CITY OF PORTLAND, MAINE
 DEVELOPMENT REVIEW APPLICATION
 PLANNING DEPARTMENT PROCESSING FORM
 DRC Copy

Single Family Home 40'x 28'
 Project Name/Description

RE: Application for Single Family House, Farragut Street, ID # 2005-0139

Upon review of the site plan, the City's Planning Division has the following comments:

SKETCH PLAN		
90-94 FARRAGUT STREET PORTLAND, MAINE		
MADE FOR		
REALI REALTY 949 BRIGHTON AVE PORTLAND, MAINE 04102		
JOB#	00000	DATE: 06-14-05
BOOK#	770	SCALE: 1" = 10'
DISC#	N/A	PREPARED BY
FILE#	N/A	STEPHEN M. SELLECK (207) 797-0724
		80 FARRAGUT STREET PORTLAND, MAINE 04103

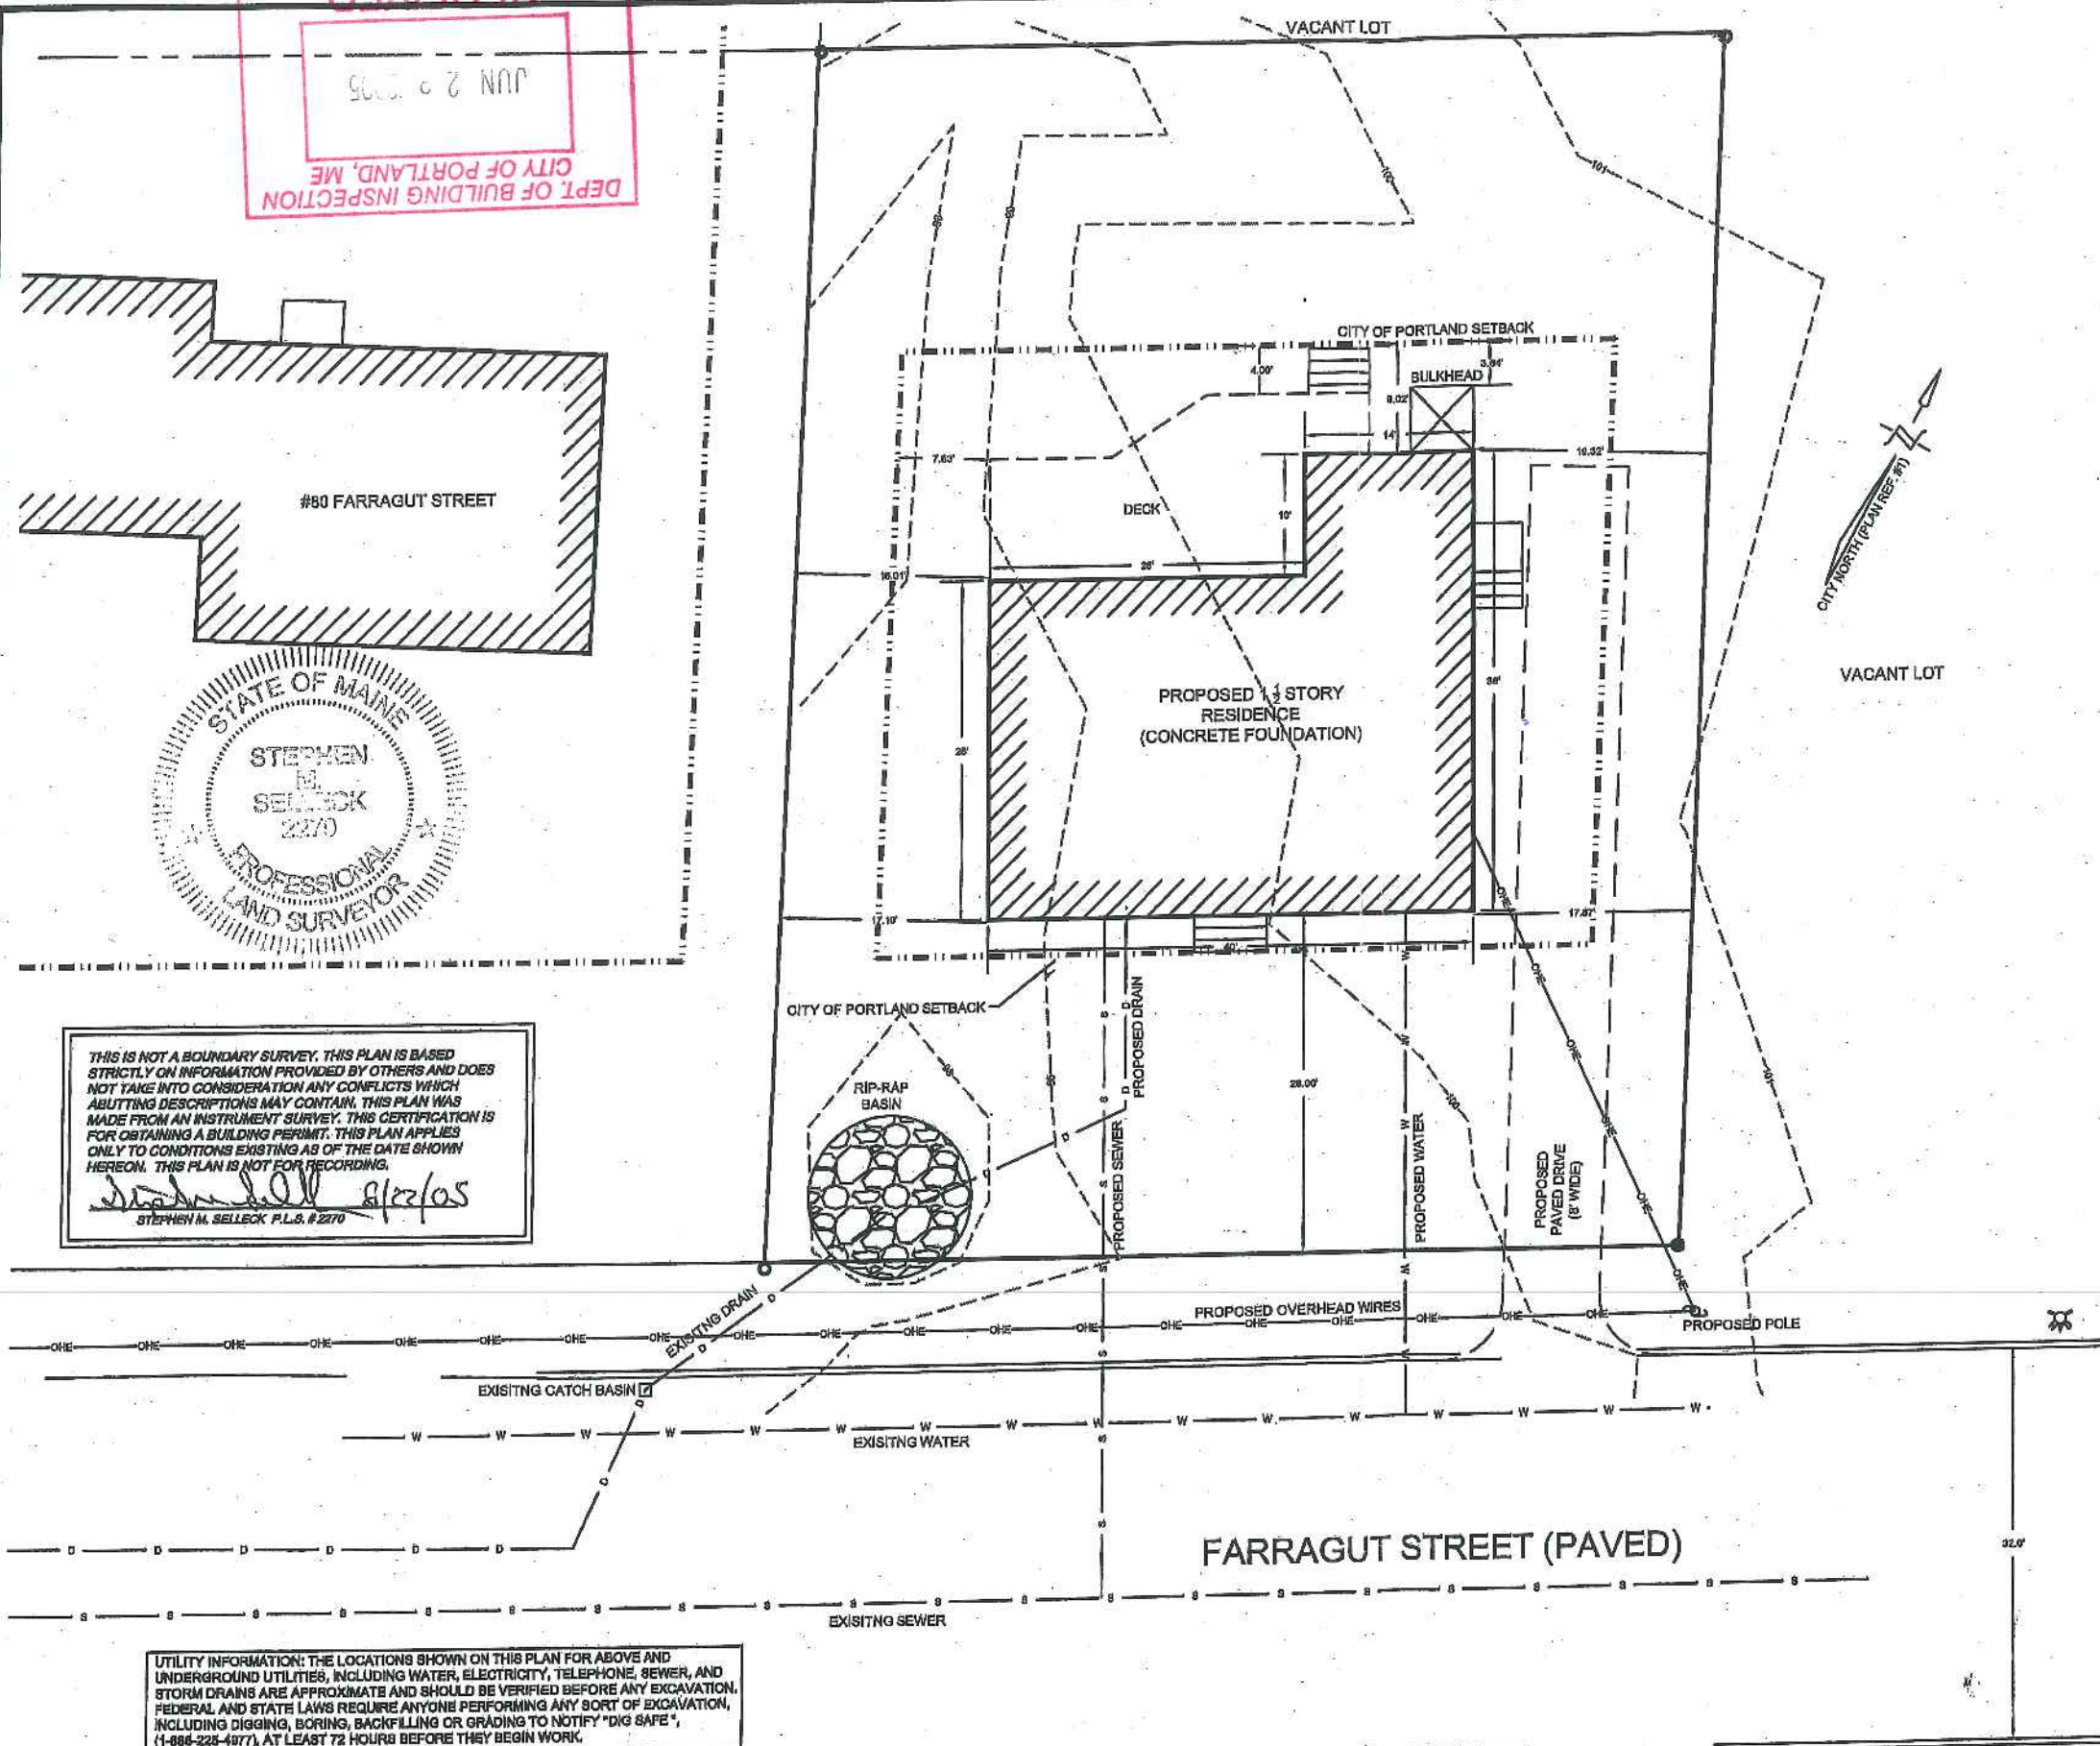
1. Please provide proposed grading/topography on the lot. This should match the previously approved grading as shown on the Farragut Street Extension plans approved on April 16, 2003. Add to plan.
2. Please note the Finish floor elevation. This should be tied into the same elevation data as your proposed topography.
3. Add the distances of the lot lines to the site plan.
4. Two street trees are required for single-family development, along your street frontage. Add to plan.
5. A backflow preventer is highly recommended on the 4" storm drain lead. Please add a note to the plan.
